# MP 08\_0244 Project Application for Mixed Use Development

## RESPONSE TO KU-RING-GAI COUNCIL'S SUBMISSION

RL 94.00  
**LOWER GROUND  
 FLOOR PLAN**  
 SK 0 2

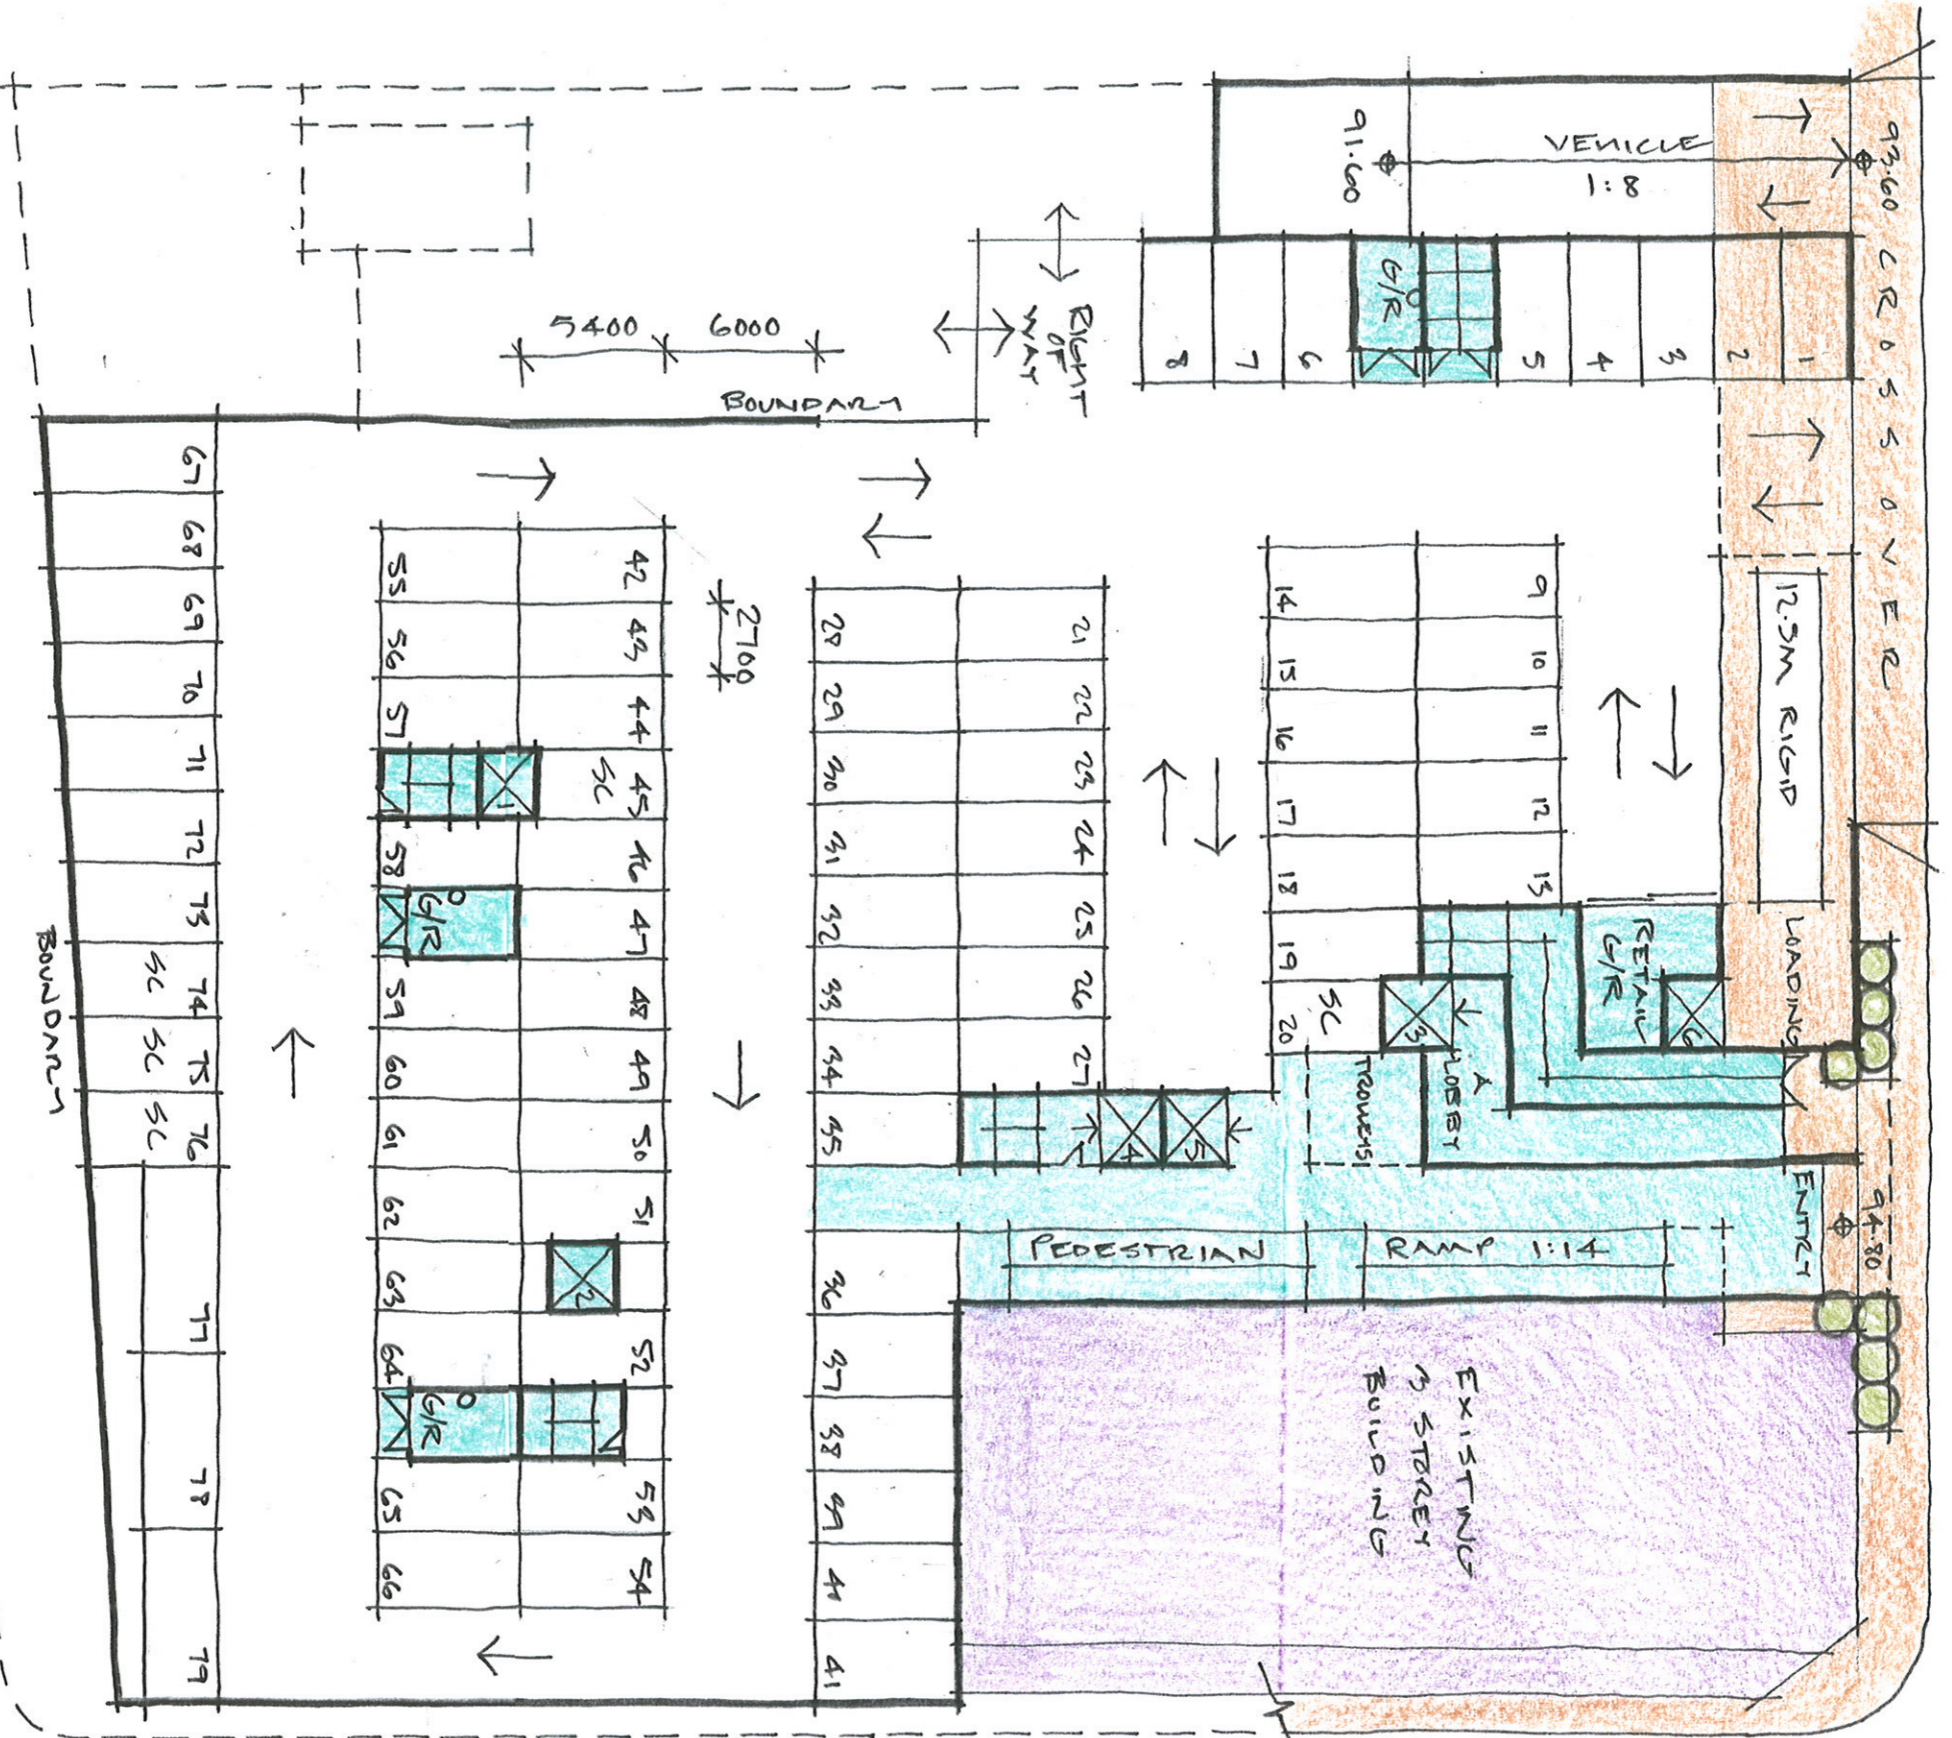
There is concern there is no separation between retail and residential car parking.	The revised layout of the car park provides for the separation of the residential and retail car parking areas.
The car parking space and aisle width dimensions do not comply with AS2890.1 for user 3A (short term, high turnover rate) on the lower ground level retail parking which requires 2.6m wide spaces and 6.6m wide aisle widths.	As set out within the Traffic and parking report at <b>Appendix G</b> , the geometric design of the proposed car parking facilities have been designed to comply with the relevant requirements specified in Australian Standard AS 2890.1 in respect of parking bay dimensions, ramp gradients and aisle widths.
Accessible parking layout does not comply with AS2890.6.	The accessible parking layout of the car park has been assessed by PSE Access Consulting (refer to <b>Appendix L</b> ) who confirm that all areas of compliance have been catered for within the design.

There is a conflict point on the lower ground level, at the point where the proposed private right-of-way access and the retail/ residential car park ramp converge just south of the access point. This needs to be resolved by way of a priority system.	The proposed design of the vehicular access has been reconfigured to ensure that the driveway aligns with the existing right of way easement and provide the required height for the easement.
<b>Bicycle Parking and Facilities</b>	
It is unclear whether adequate bicycle parking and facilities are provided in accordance with the DCP.	Specific bicycle parking areas are provided within the basement car parking levels. These areas will provide adequate bicycle stands to cater for the development.
<b>Car Share Parking</b>	
The provision of 7 on-site car share spaces is high for a development of this scale, and the proposed tandem/ stacked arrangement would not be desirable if there are different model vehicles to be made available on site to users.	The car share spaces have been removed from the proposed development.

1 NORTH EAST ELEVATION- HAVILAH LN  
1:200

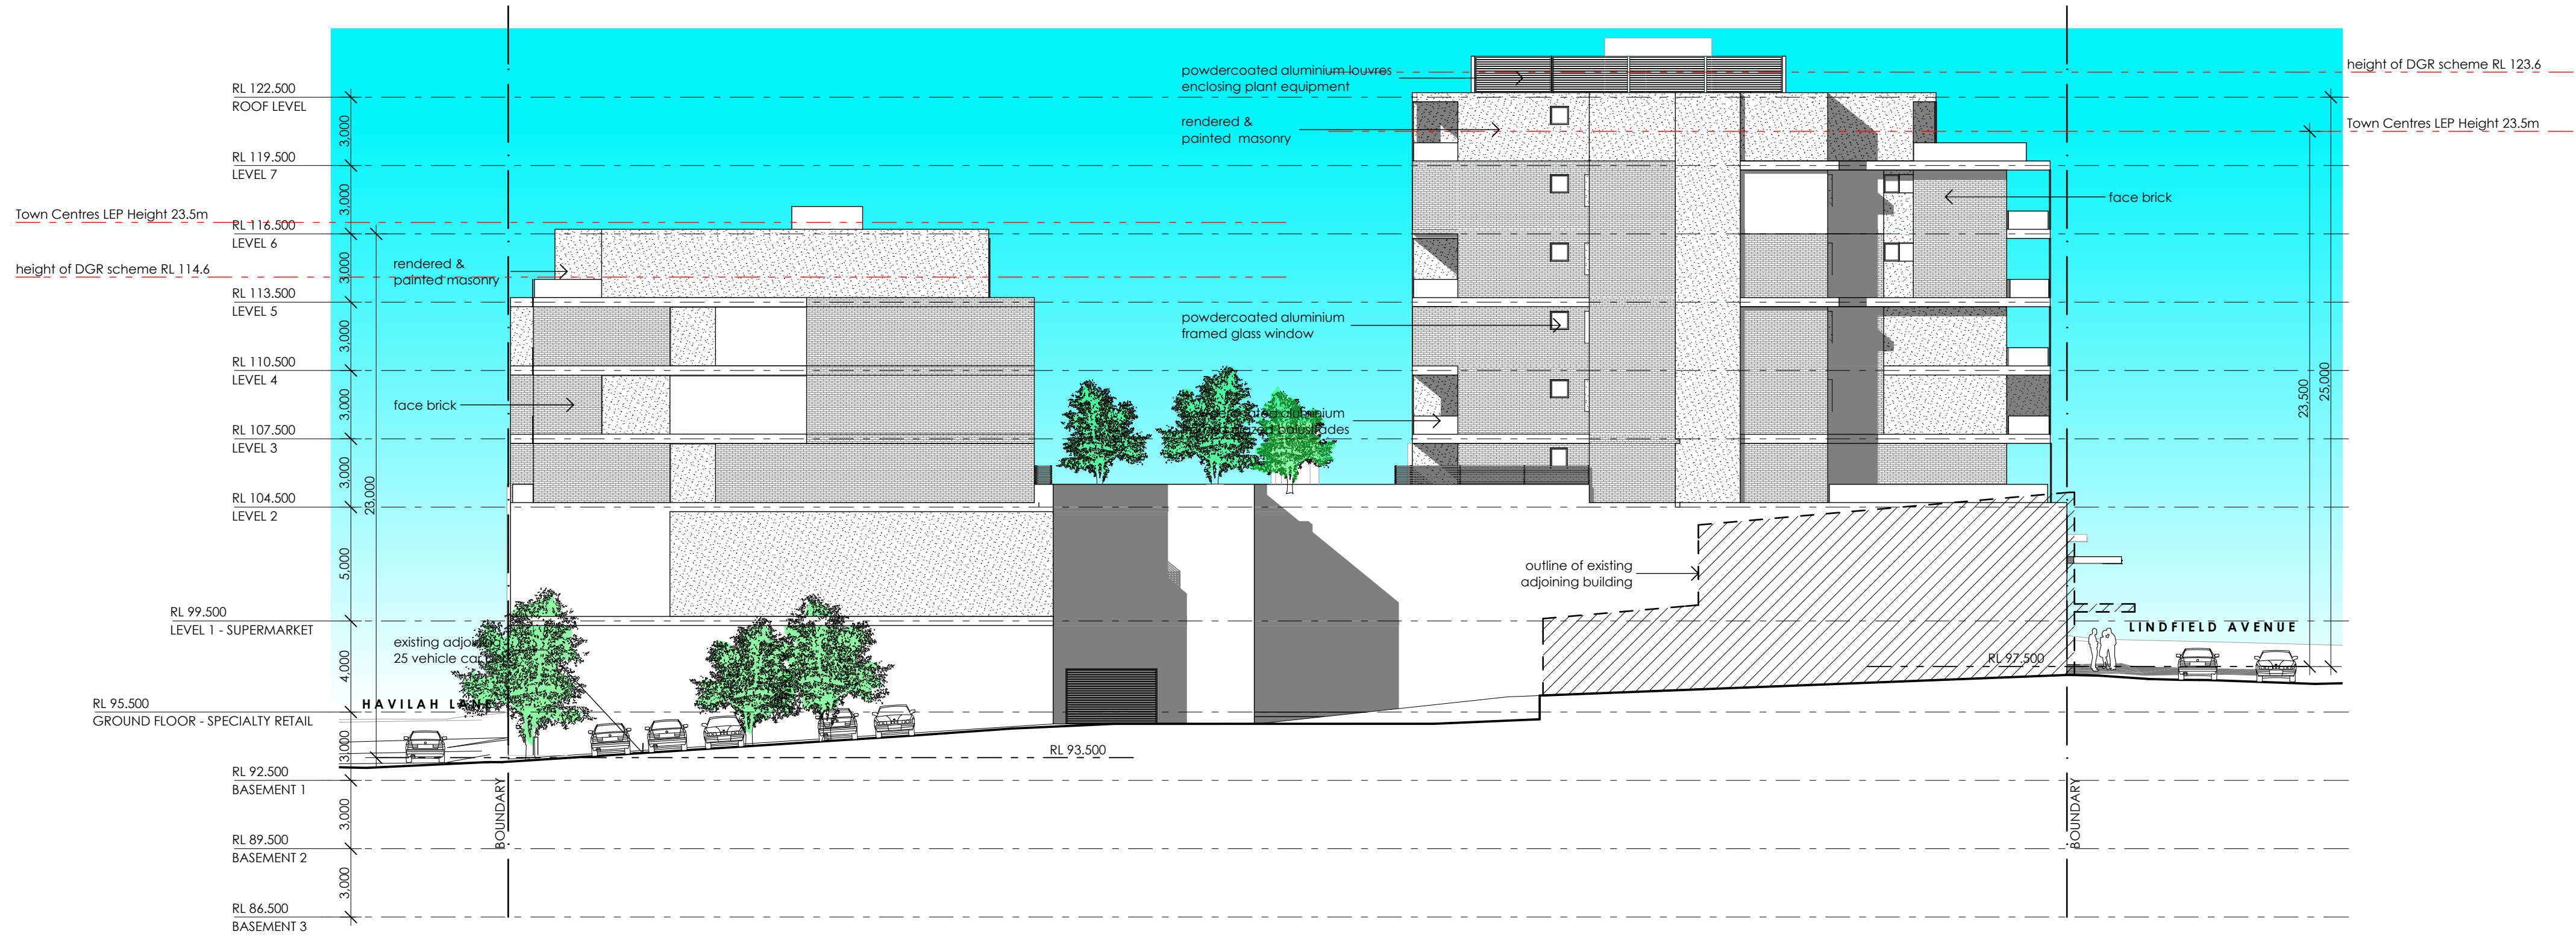
development site does not include 2 Kochia Lane, the requirement to provide a 4m setback outside of 2 Kochia Lane is therefore not a consideration in this application.
<i>Principle 5:</i> Provide building setback to Havilah Lane to allow for road modifications and new footpaths. A continuous 13m right-of-way btw Kochia Lane and Havilah St is required.	Under <i>SEPP65</i> a minimum of 18 m separation is required between habitable rooms. The proposed development would not comply with this in regards to the new development on opposite side of Havilah Lane at 2-6 Milray Street.	No setback will be provided to Havilah Lane, however the existing road reserve is approximately 13m wide, therefore it is considered this allows for appropriate vehicle access and servicing. Compliance with <i>SEPP 65</i> in regard to building separation is required to provide adequate visual and acoustic privacy and control overshadowing. As discussed at Section 2.3.5, the separation between the proposed development and the residential buildings on the western side of Havilah Lane is considered acceptable.

Principle 2: Provide increased building setback to Havilah Lane to allow for wider footpaths on both sides.	There is no widening of Havilah Lane proposed.	As noted above, it is considered appropriate not to provide the 1m setback to Havilah Lane.
Principle 3: Provide co-ordinated development that allows the provision of underground vehicle connections between basement car parks on private land and public land.	The failure to incorporate No. 2 Kochia Lane will prevent any future ability to incorporate any future connections between the proposed development and any future town square and public parking that is proposed for Council's Tryon Road car park.	Every effort to reach a fair and reasonable agreement with the owners of 2 Kochia Lane has been undertaken. As demonstrated on Plan DA 33A 2 Kochia Lane could be integrated into the development in the future. The proposed development however provides a main retail entry and the residential entry on Kochia Lane to promote connections with the future town square.
